# Consultee Comment for planning application 6/2022/0922/FULL

| <b>Application Number</b> | 6/2022/0922/FULL  |
| <b>Location</b>           | 11 Tolmers Gardens Cuffley Potters Bar Hertfordshire EN6 4JE  |
| <b>Proposal</b>           | Conversion and extension to existing single dwelling house to create 4x 1 bed apartments with associated infrastructure   |

DRAWING
Proposed Plans

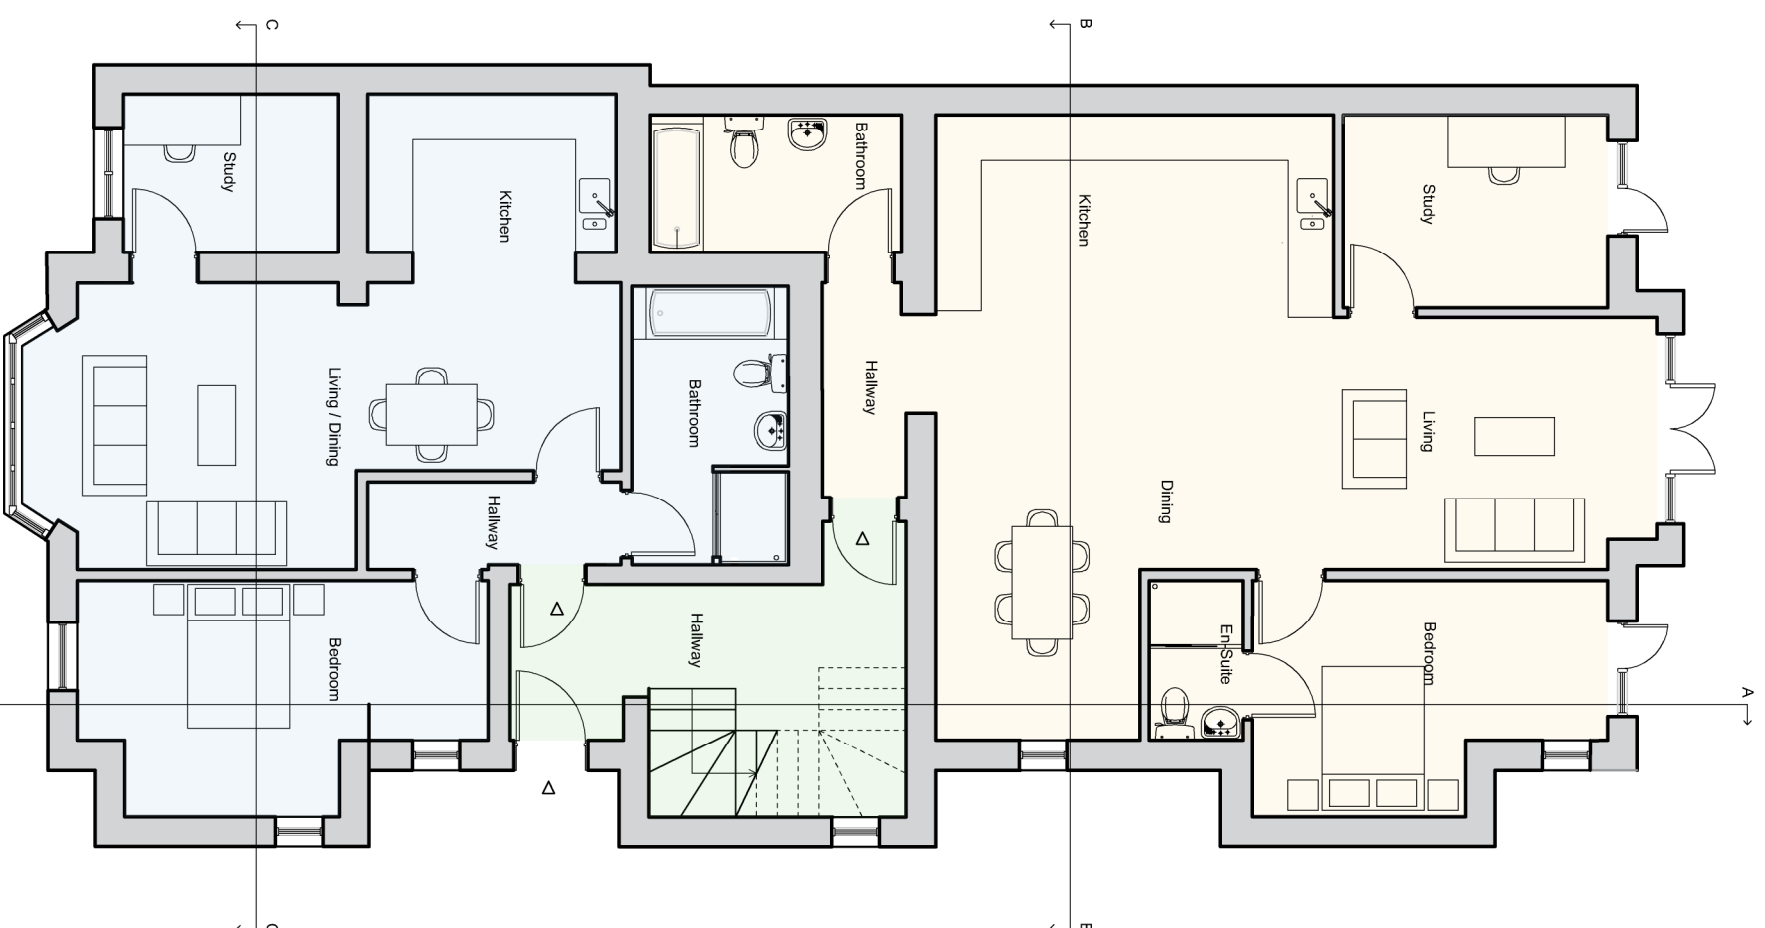
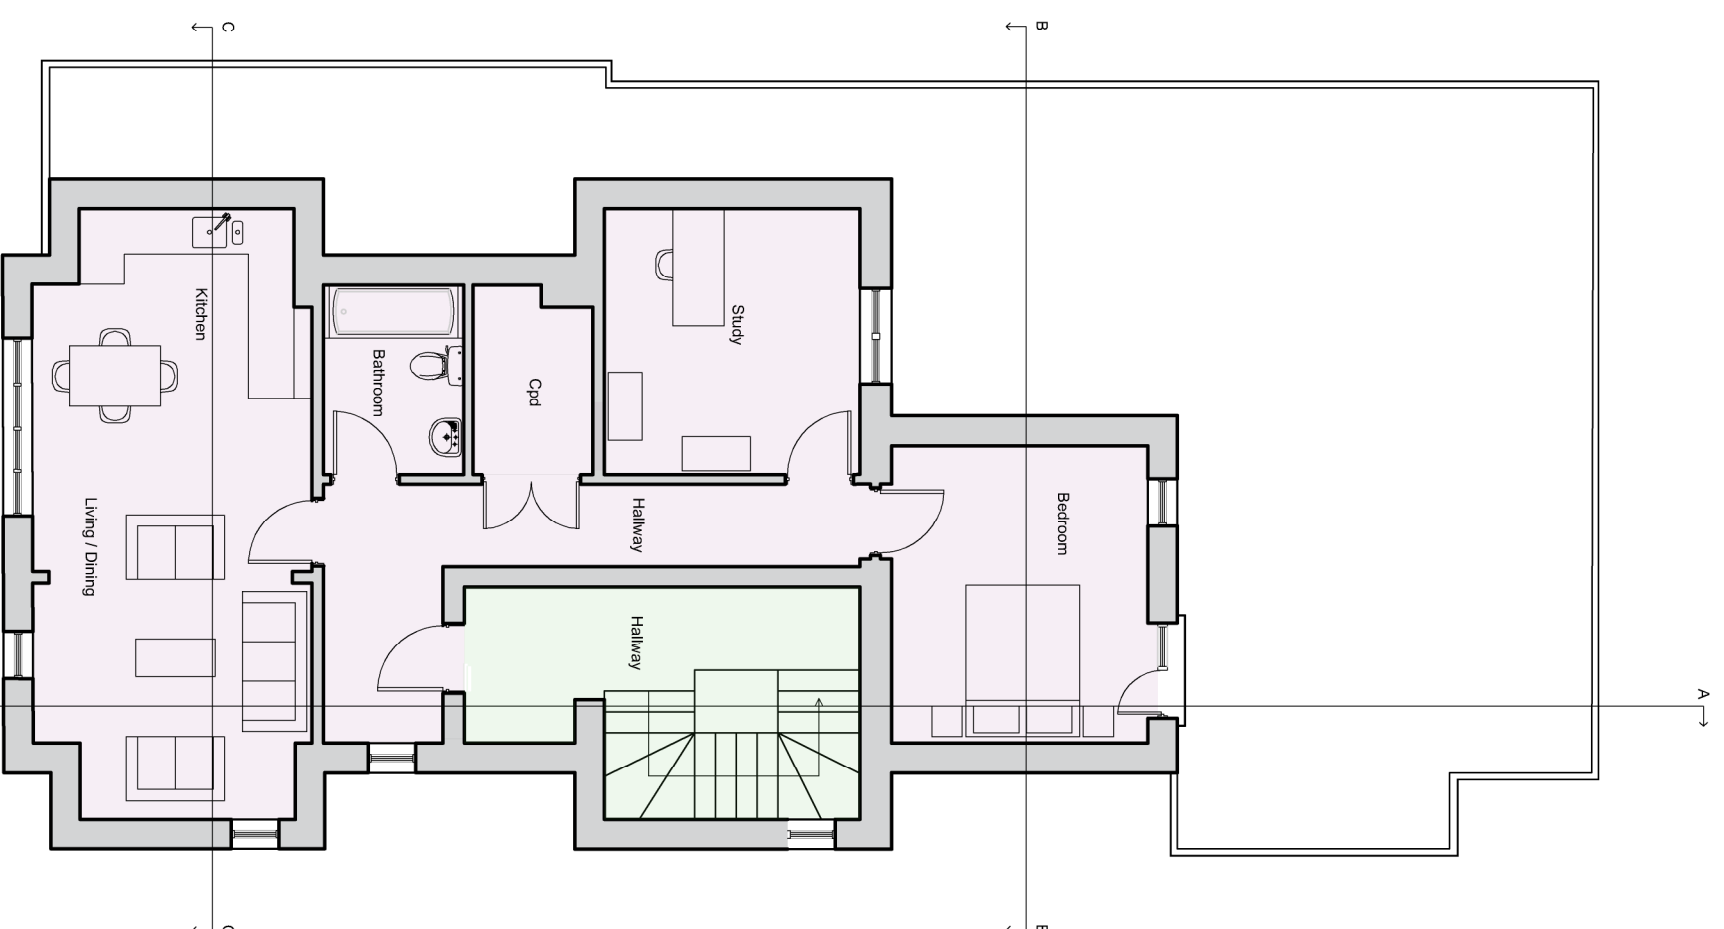
| <b>Comments</b>           | 31/05/2022 Lorraine Davis - The properties could be incorporated onto the existing ARRC scheme. Each 1 bedroom flat will require 100l refuse capacity. I note it is intended to share the refuse store area of No 12...please confirm the distance from the new flats to the bin store as there is maximum carry distance in the BS Code of Practice (attached) one can expect resident to carry their waste. |
